### MEMORANDUM

SUBJECT: Riste Short Plat SP-15-0007

Subject: SUB15-00007, Riste Short Plat  
SR 821, MP 6.0 vicinity

DRAWING TYPE: SHORT PLAT APPLICATION

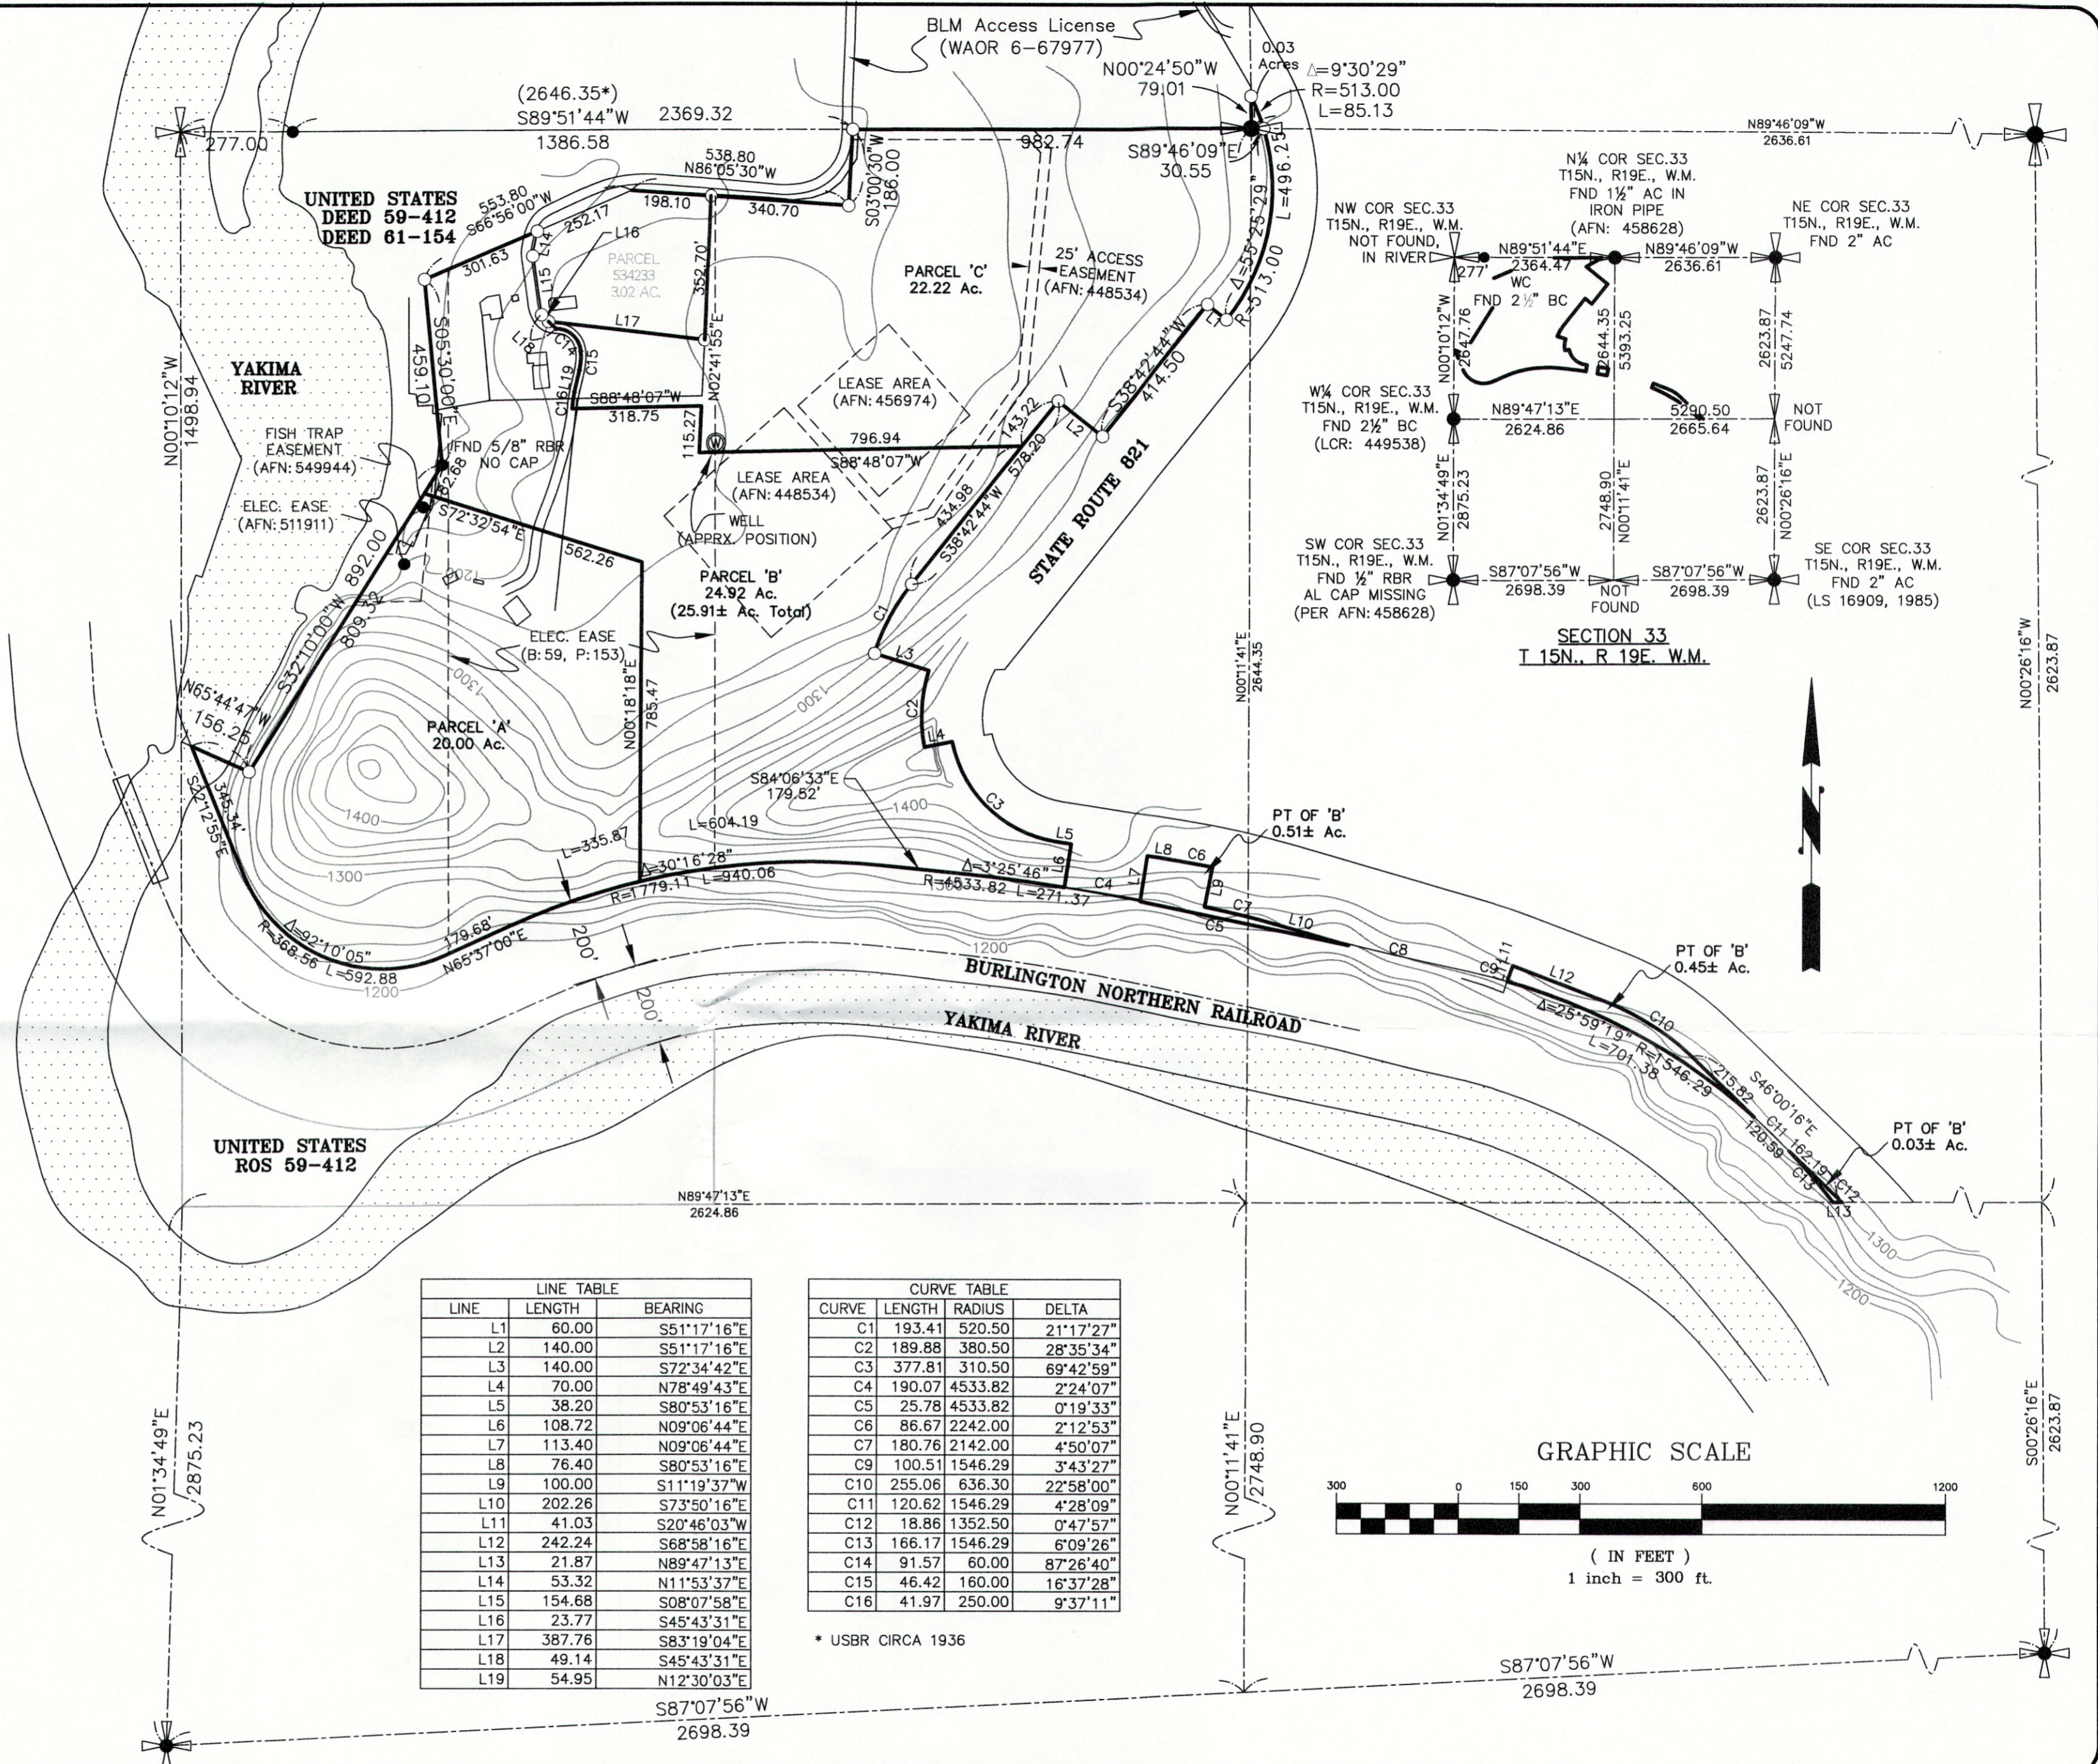
1. An access easement for Parcel "A" of the Riste Short Plat needs to be shown on the face of the short plat.
2. No driveway or road shall be constructed within five feet of the side yard boundary, unless the driveway or road is part of an easement shared with the neighboring property owner.
